From: [REDACTED]
To: [Jones, Hefin](#)
Cc: [REDACTED]
Subject: SLP: Turfhill Park
Date: 20 February 2020 17:32:00
Attachments: [REDACTED]
Importance: High

The SLP – Heronscourt & Colville Gardens Residents Associations responses to the ExA' s Questions of the 12th December by Natural England and of the 13th January 2020 by the Applicant

Development of the route – Sub-options F1a, F1b and F1c

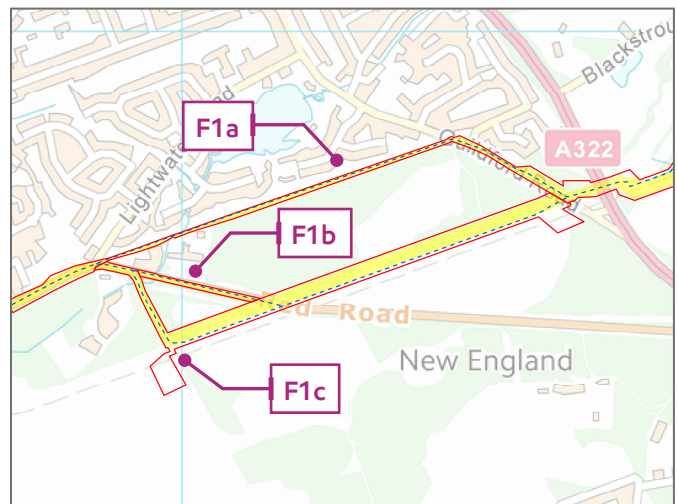
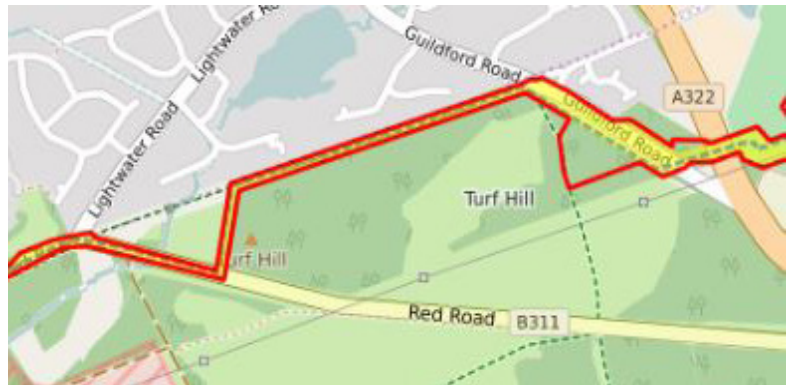
The Applicant states incorrectly that the F1a route would avoid direct impact on residential properties. It obviously did not consider the impact of tree removals on flood risk, noise, pollution and the value of the amenity to the Community.

Without detailed comparative studies of all of the respective impacts of the two routes, it is hard to understand how the Applicant could come to the conclusion that F1a was the preferred route.

The Applicant makes mention that only 17 of the surveyed trees would be removed on F1a. It makes no mention of the 100 or so, of lesser diameter than 250mm that will be removed, nor any mention of any trees being affected on the Folly or Guildford Road sections. It also ignores the substantial damage that will be done to the roots of another 70/80 mature trees which border either side and extend across the Order Limits of F1a+, possibly rendering them unsafe.

It is agreed that the habitat across the centre of Turfhill is suitable for sand lizards, however the Order Limits of F1c are not. Contrary to the Applicant's earlier statements that sand lizards had spread throughout the Park, the latest SARG sightings report and confirmed by the Applicant's map at 2.7 ii), only a single sand lizard has been recorded south of the access track well away from the Order Limits, which extend northwards from the centre line of F1c.

As evidenced above, It is extremely unlikely that any sand lizards migrating from their release site would find any suitable habitat along the Order Limits of F1c and therefore be exposed to any disturbance during construction. And as construction is during their hibernation period, there would be none making the journey across F1c, so presumably no need or opportunity to trap and translocate them.

Mitigation would seem to be limited only to fencing off the northern edge of the Order Limits for a relatively short distance along the route adjacent to the Release Area and the single small area, south of the Order Limits.

Whilst it is not disputed that the general area of F1c contains more habitat suitable for sand lizards than F1a, the specific area, the Order Limits, does not. As has been mentioned in previous submissions, the ground conditions, the dense borders of gorse and the daily movements along the track are all contrary to what sand lizards require.

Without knowledge of the actual route of the water line along F1a, which is due to be available after March 6th, by making some basic assumptions for the most favourable routing of this line, as below, then it becomes apparent, even then, how difficult it will be

- F1a is absolutely straight with no bends
- the water main is laid precisely 3 metres from the northern fence line all along F1a (Affinity Water indicated that this is approximately where they would expect it to be)
- its trench and southern easement extends a further 3.5 metres into F1a
- the Applicants line has a 3 metre easement from the southern boundary of the Order Limits
- the Contractor lays the fuel line precisely alongside the southern easement
- the Applicants trench and northern easement extends a further 4 metres into F1a,

which leaves 1.5 metres of separation between the two pipeline easements and an hydrocarbons pipeline at the very best, within 4.5 metres of the plastic water main.

- from viewing F1a from the Guildford Road, it is apparent that it bends significantly to the right and is out of sight about halfway along its length.
- it is obvious that at the Guildford Road end, the water main enters some 8/10 metres on the southern side of F1a and therefore has to move over towards the fence line somewhere along its early length.
- it is unlikely that this line will have been laid precisely 3 metres away from the fence line in the late 1970, all along its length.
- it is unlikely that the Applicants contractor can lay its pipeline with only 1.5 metres of error margin between the two easements given it has to negotiate extensive root structures all along the route from bordering trees.

Given all of the above, it is therefore very unlikely that the Contractor could stay within the Order Limits or not encroach on Affinity's easements or avoid having this fuel line in very close proximity to the plastic water main .
